Planning Reference 2023/92576

This application seeks approval to the demolition of outbuildings and erection of a detached dwelling with detached garage/store at land adjacent to 1, Long Moor Lane, Shelley, Huddersfield.

BLOCK PLAN - 1:200

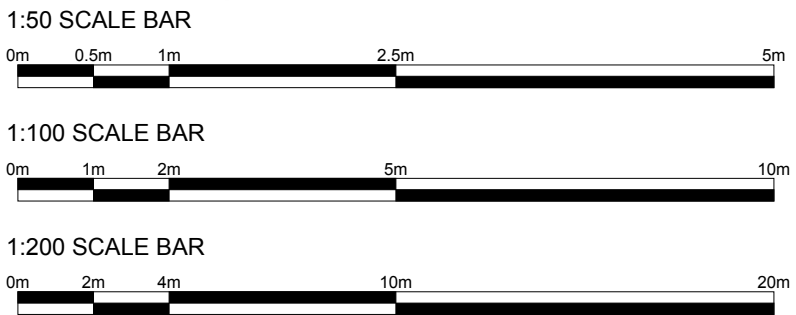
The highways consultation response dated 13th November concluded that whilst these proposals are considered acceptable this application provided insufficient information. Further details were required as follows:

- 1, Sight lines of 2.4 x site frontage should be shown from the proposed site entrance onto Brook House Lane. To be cleared of all obstructions to visibility exceeding 1 m in height.
- 2, A bin collection point should be provided to enable bins to be presented on collection day without either obstructing the highway or proposed driveway.

The applicants have provided acceptable revised plans and these proposals are now considered acceptable to Highways Development Management.

Before development commences, the sightlines of 2.4m x the full site frontage along Brook House Lane as shown on WHP plan number 23-0038-11 shall be cleared of all obstructions to visibility exceeding 1 m in height and these shall be retained free of any such obstruction. Reason: To ensure adequate visibility in the interests of highway safety.
